Sheringham Shoal and Dudgeon Offshore Wind Farm Extension Projects

The Applicant's Comments on the Maritime and
Coastguard Agency's Deadline 7 Submission

Document Reference: 22.25

Sheet 2

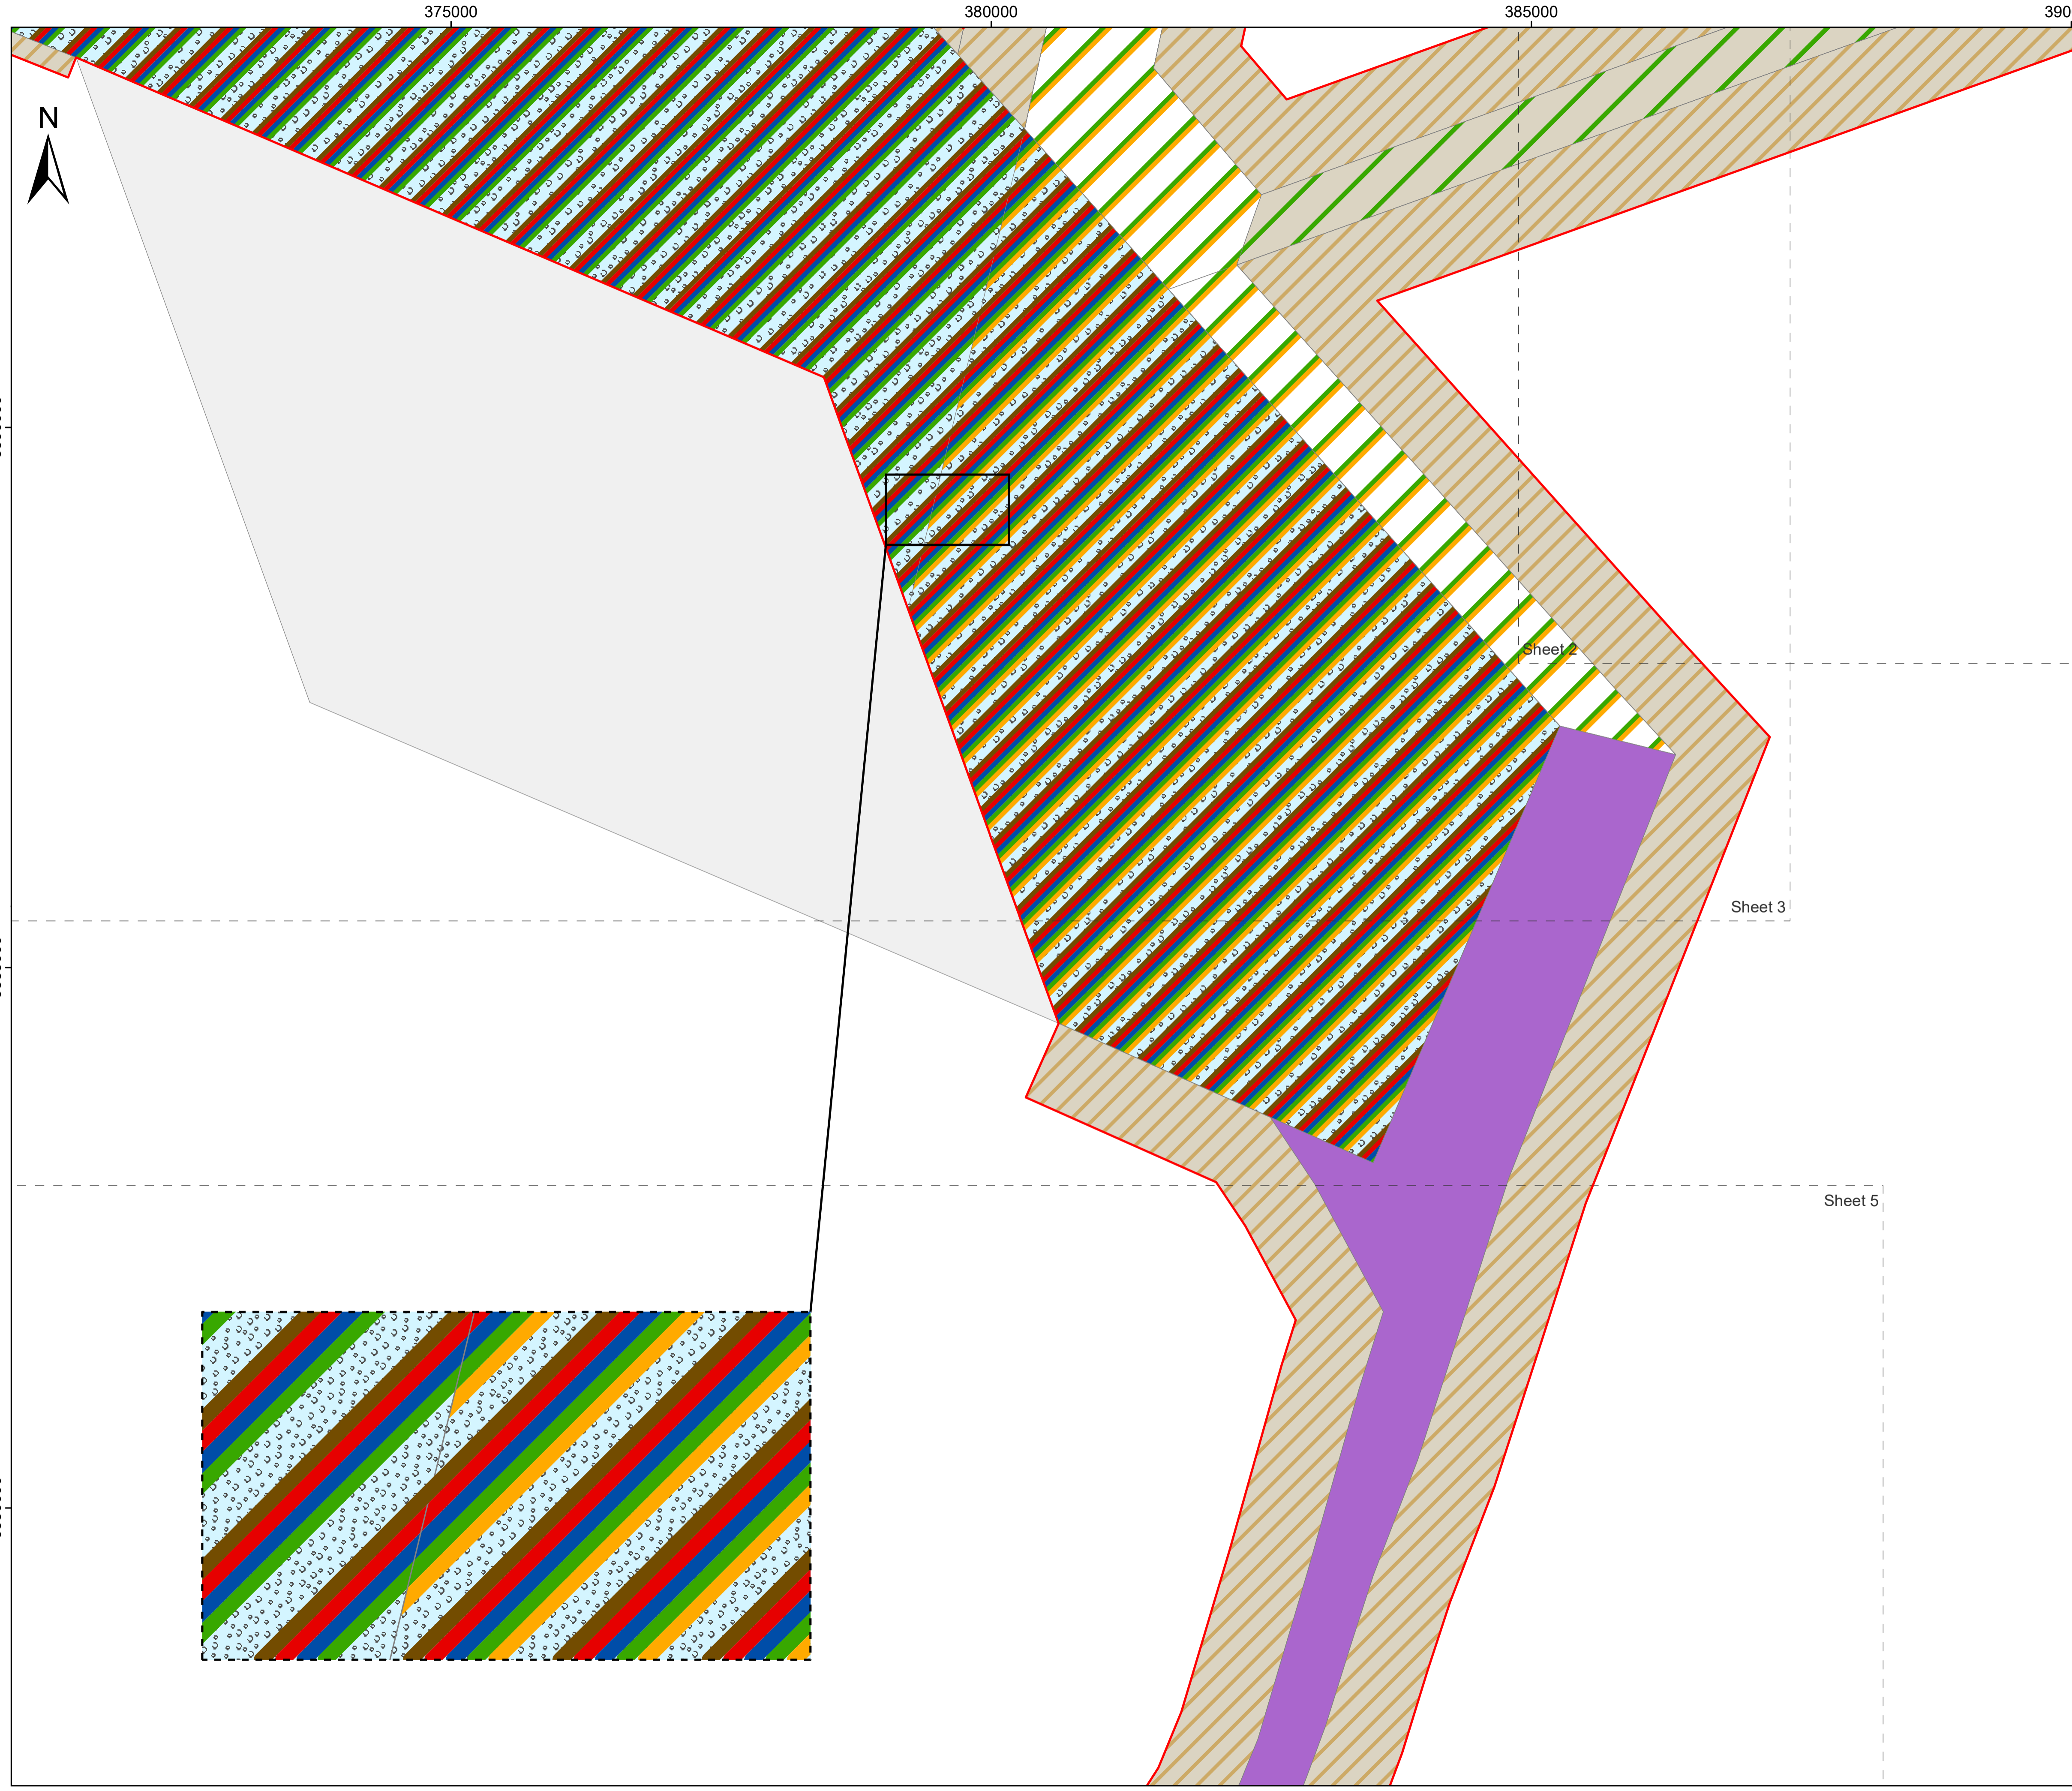
ID	Question	Maritime and Coastguard Agency Responses	Applicant's Comment
	<p>a) Applicant and MCA, show this exclusion zone on a map/diagram with an easily recognisable title.</p>	 <p>Figure 1 Recommended 'exclusion area' (blue hatched area) or reduction in f</p>	
	<p>b) In its post Examination considerations, if the ExA considers it is essential to include a provision for an infrastructure free zone in line with MCA's representations (as outlined in Section 7 and Figure 2 (Recommended Boundary Amendment) of their submission at Deadline 5) [REP5-081], Applicant and MCA advise if the map/diagram would need to be included as a certified document or if it should be included in the ES or the Offshore Project Environmental Management Plan.</p>	<p>MCA would suggest that the image showing the 'exclusion area' is referenced in the DCO as a certified document and included in pre-construction plans and documentation.</p>	<p>It is the Applicant's view that, should it be deemed essential by the Secretary of State to include provision for a surface structure free area then this would be most appropriately secured via the Offshore Works Plans without need to certify the attached figure or have it included in any other post consent documentation. See the response to Q4.19.1.6c of The Applicant's Responses to the Examining Authority's Fourth Written Questions [document reference 21.5] and the Works Plans (Offshore) (Without Prejudice) (Revision B) [document reference 2.7.2].</p>

<p>c) Applicant and MCA, provide dDCO drafting, be it a new article, new</p>	<p>MCA would suggest that latitude and longitude coordinates of the 'exclusion area' are included</p>	<p>The most straightforward mechanism to secure a surface structures free area within the Order Limits at DEP North</p>

ID	Question	Maritime and Coastguard Agency Responses	Applicant's Comment															
	<p>requirement or amendment to an existing requirement, and any relevant definitions that puts the exclusion zone into effect.</p>	<p>in the DCO, for example: None of the infrastructure listed in Work No.*** may be installed within the area defined by the coordinates as specified below and no part of any wind turbine generator, including its blades, may overfly into the area:</p>

ID	Question	Maritime and Coastguard Agency Responses	Applicant's Comment
			<p>ALARP Statement</p> <p>The MCA state they <i>'must ensure that the risks to vessels remain tolerable (if ALARP) or acceptable at all times. It is not acceptable to MCA to say that the risks to vessels are tolerable if, for even a short time, they are exposed to a hazardous area with an unacceptable risk'</i>. The Applicant confirms that all risk (as evidenced by the NRA [APP-198]) are within ALARP parameters i.e. Tolerable (if ALARP) or Broadly Acceptable.</p> <p>Finally the Applicant has agreed final SoCGs with Trinity House [document reference 12.19] and the UK Chamber of Shipping [document reference 14.22] regarding the ALARP statement and whilst the Chamber advocates for more sea room their disagreement of impacts is not material to the in-isolation impacts significance as assessed by the Applicant.</p>
Q4.19.1.6	<p>Without prejudice mitigation wording</p> <p>At ISH7 [EV-096] [EV-100] it was suggested that a potential mitigation would be an exclusion of wind turbines and any other associated infrastructure from an area in between and to the west of the Mid-Outer Dowsing buoy and Dudgeon buoy, thus allowing greater sea room. The ExA acknowledges that the Applicant strongly opposes this measure and would not wish it to be proposed. Nonetheless, to aid the ExA's understanding of the possibilities before it, and to inform the SoS's decision, provide the following information without prejudice:</p>	<p>The image below (Figure 1) shows MCA's recommended 'exclusion area' or reduction to the red line boundary:</p>	<p>Noted.</p> <p>The Applicant refers to The Applicant's Comments on Maritime and Coastguard Agency Deadline 6 Submission [document reference 21.11] and the response to Q4.19.1.6 of The Applicant's Responses to the Examining Authority's Fourth Written Questions [document reference 21.5] which provide its justification for providing the alternative without prejudice surface structures free area.</p> <p>See the Works Plans (Offshore) (Without Prejudice) (Revision B) [document reference 2.7.2].</p>
